Regarding: Project PR-2019-002496 at Barstow and Alameda NE
Currently scheduled for hearing on 7/17/2019

I respectfully offer the following comments and requests for consideration by the DRB regarding the Site Plan application for the above identified project.

4 Parking Stalls Details
1/8" = 1'-0"

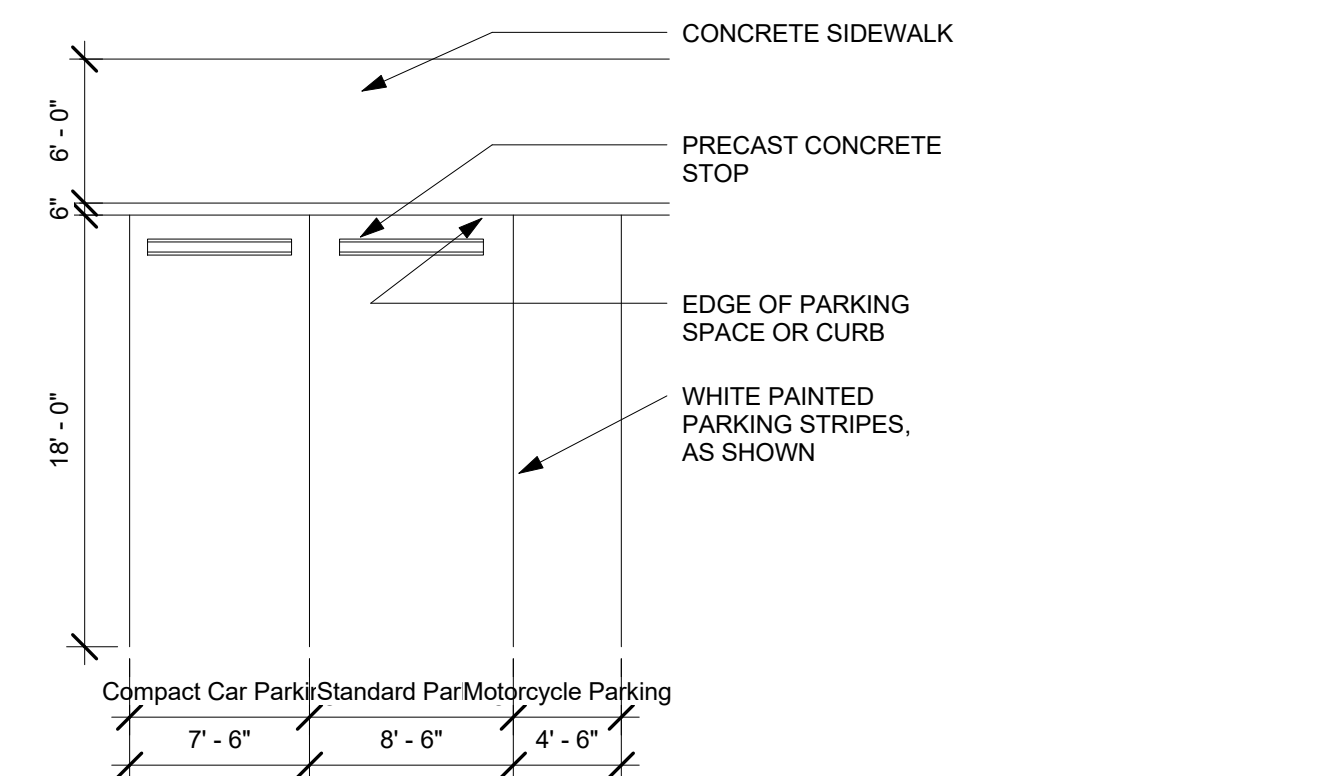
- 1.) While the applicant's design package provided a detail for parking spaces on the north side of the parking lot, it lacks any detail for the parking on the south side of the lot adjacent to the property line and privacy walls of the existing property owners. We have been told there will be a 1 to 2 foot barrier wall/curb to preclude encroaching on the landscaping [IDO section 5-6(C)(5)(e)] and more importantly, help prevent a vehicle overdriving the parking space and damaging the privacy wall or entering the adjacent property. Supposedly, this detail will be in something called the drainage plan. Please make sure that it is as this is very important for safety reasons.

1 Site Plan - East
1" = 20'-0"

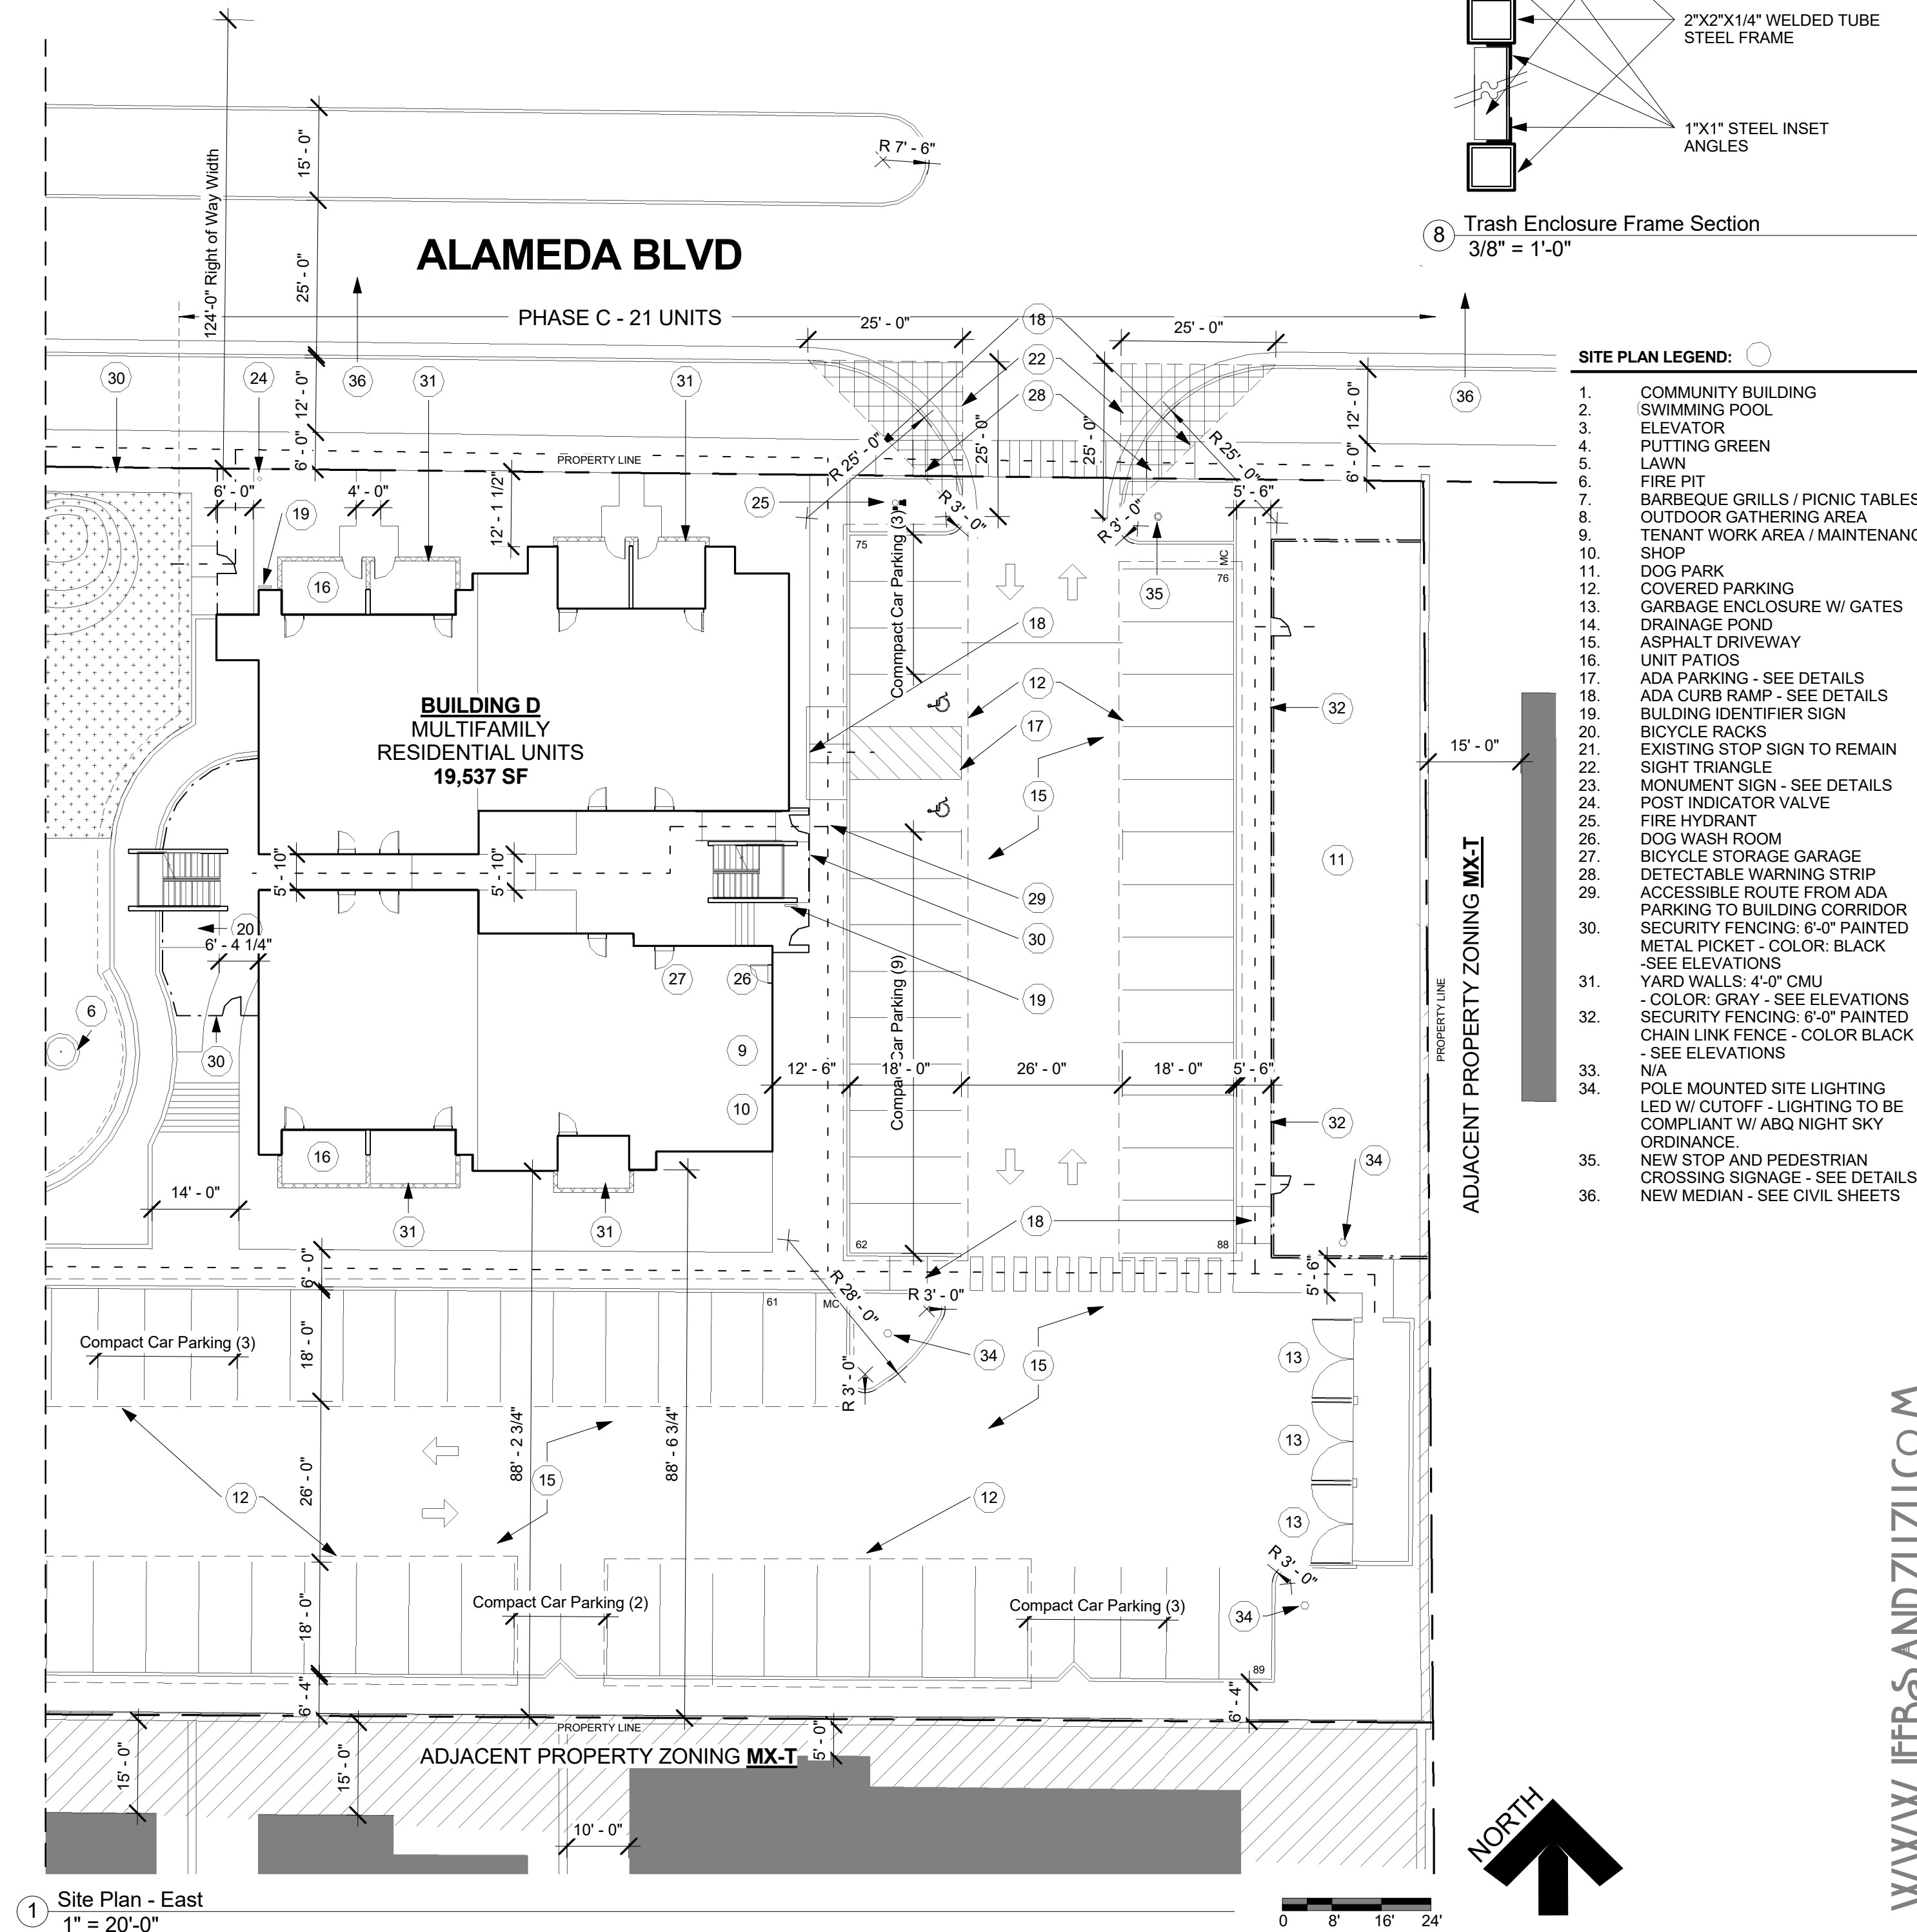
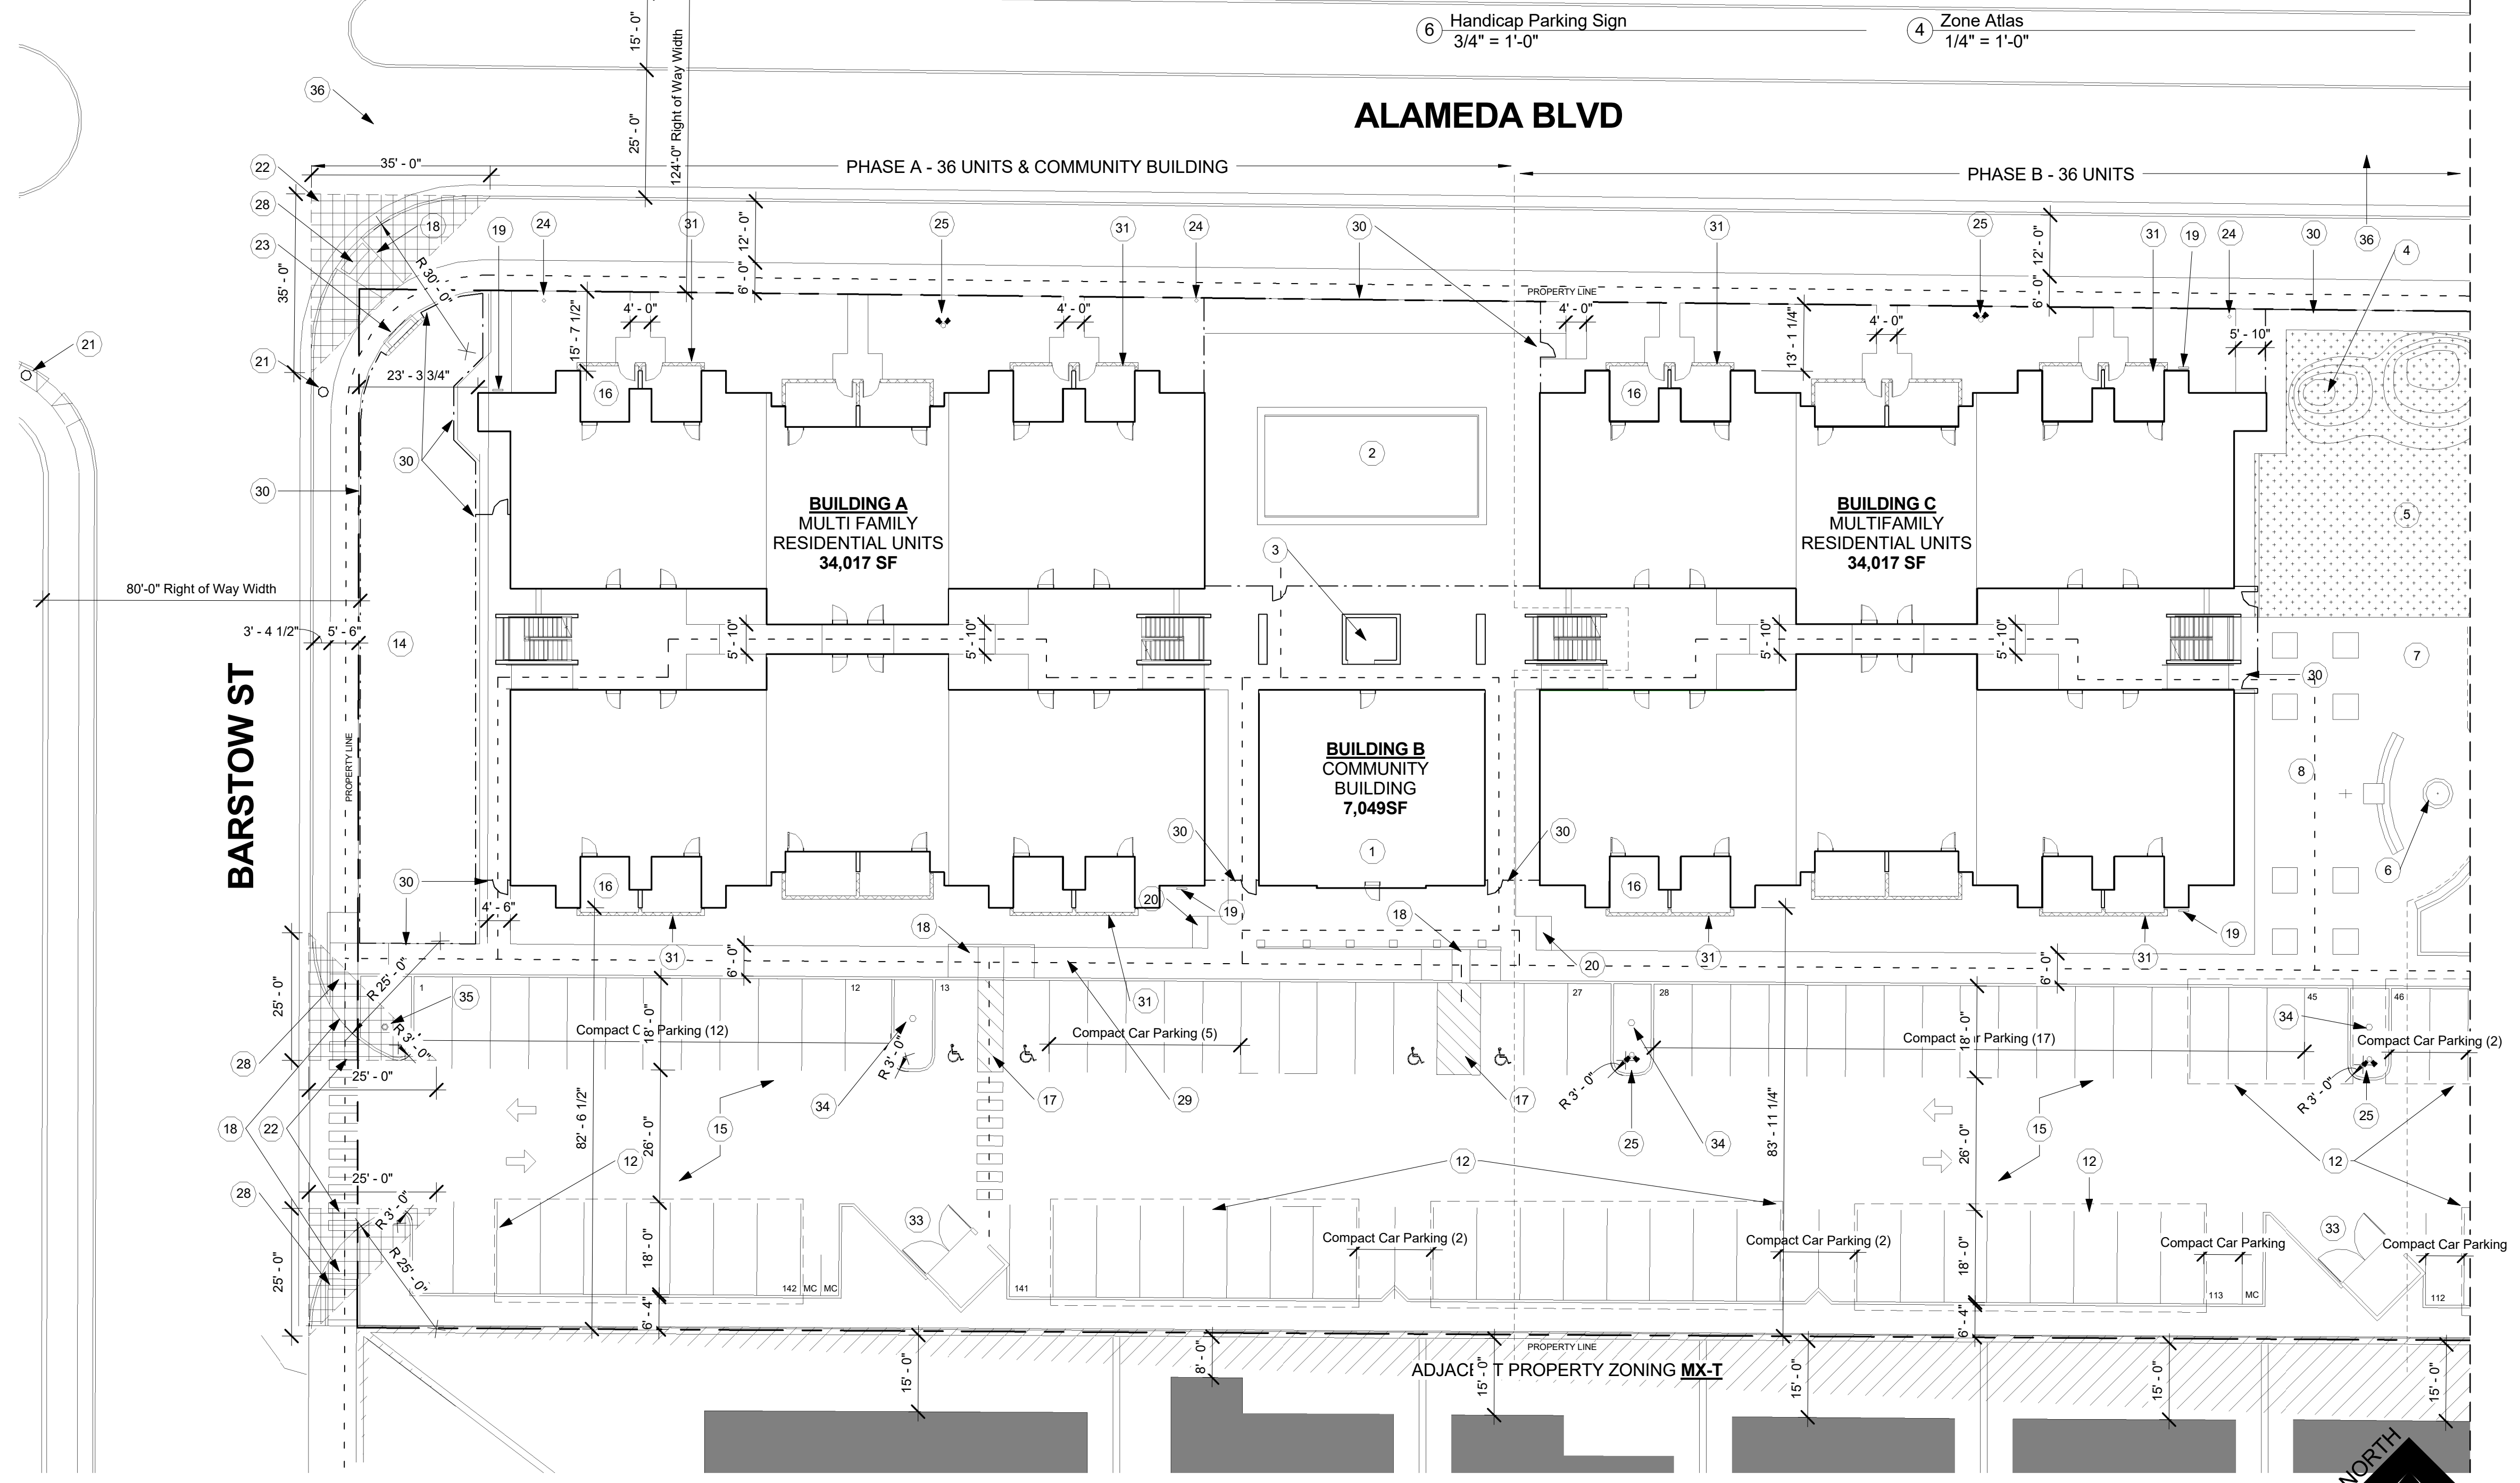
- 3.) 5-6(F)(1)(i) subsection 2 regarding rear parking lot edge landscaping. Once again, in trying to cram too much into too little, this infill project would cause problems. In this case, with only a 6' planting strip against the south property line, trees intended to provide parking lot shade and visual screening are problematic. The visual screening in this case has more to do with screening between the 3 story building and the single family homes than with headlights. As the deciduous trees mature, their canopies will encroach upon the adjacent property owner's primary structures and their root system risk damaging the privacy wall. The adjacent property owner's backyards are on the north side of their property and don't necessarily need or want more shade. This subsection gives the planning director some discretionary authority to approve alternate plans. We recommend city planning, the applicant and the adjacent property owners work together to identify a better solution for shading and screening.
